**Administrative Authorization Decision – Portland Maine**

**In'Finiti Fermentation and Distribution**

**250 Commercial Street**

The Administrative Authorization for 250 Commercial Street was approved by Barbara Barhydt, Development Review Services Manager on June 1, 2012 with the following Condition(s) of Approval listed below:

Updated Record Site Survey
 Union Wharf
 Portland, ME

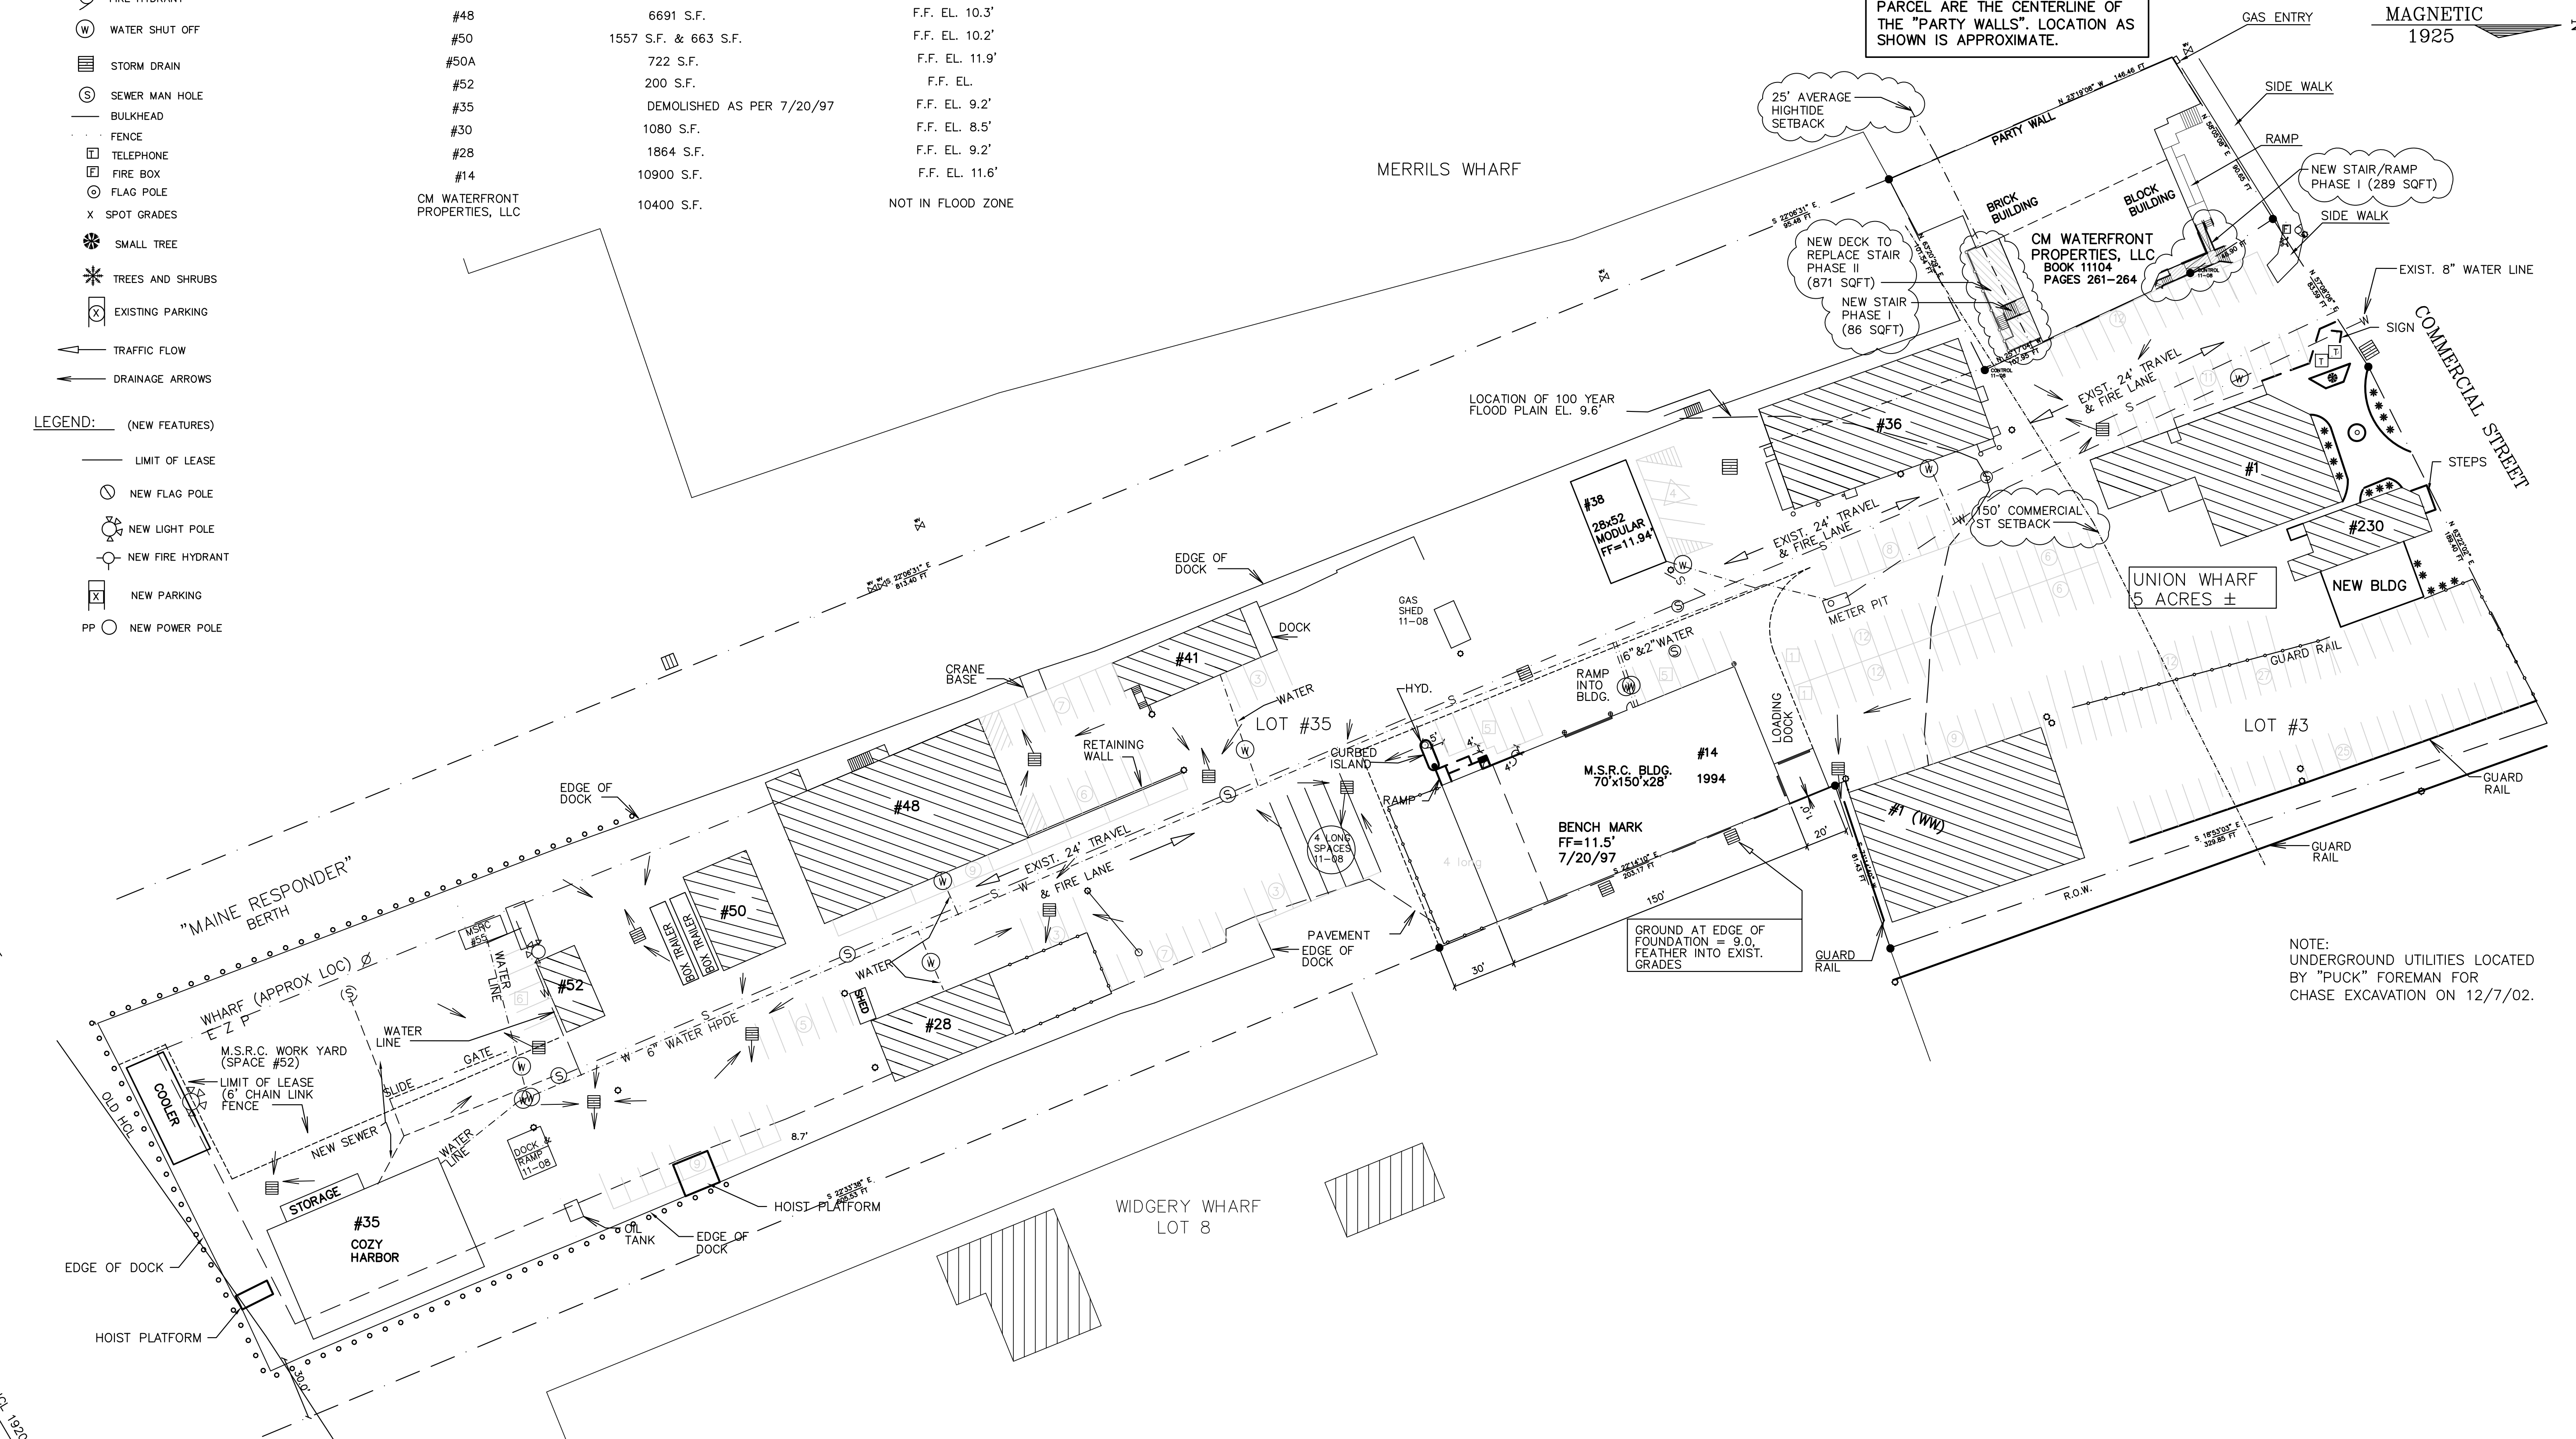
a) Is the proposal within existing structures?	Yes	Renovation and exterior changes
b) Are there any new buildings, additions, or demolitions?	Limited demo and exterior deck	Plan revised to eliminate the deck and only has 2 exit stairs

c) Is the footprint increase less than 500 sq. ft.?	yes	The 800 sf deck is not approved and has been removed from the plan dated May 23, 2012
d) Are there any new curb cuts, driveways or parking areas?	no	No

1. The applicant shall obtain an Industrial Pre-Treatment License from the Department of Public Services prior to the issuance of a building permit. Please contact Steve Harris at 874-8843.
2. This approval is for the site plan dated May 23, 2012, which does not include a deck. Any proposal for an exterior deck shall be submitted for the appropriate level of site plan review.
3. Standard Condition of Approval: The applicant shall obtain all required City Permits, including building permits from the Inspection Division (874-8703) and any other permits required from the Department of Public Services (874-8801) prior to the start of any construction.
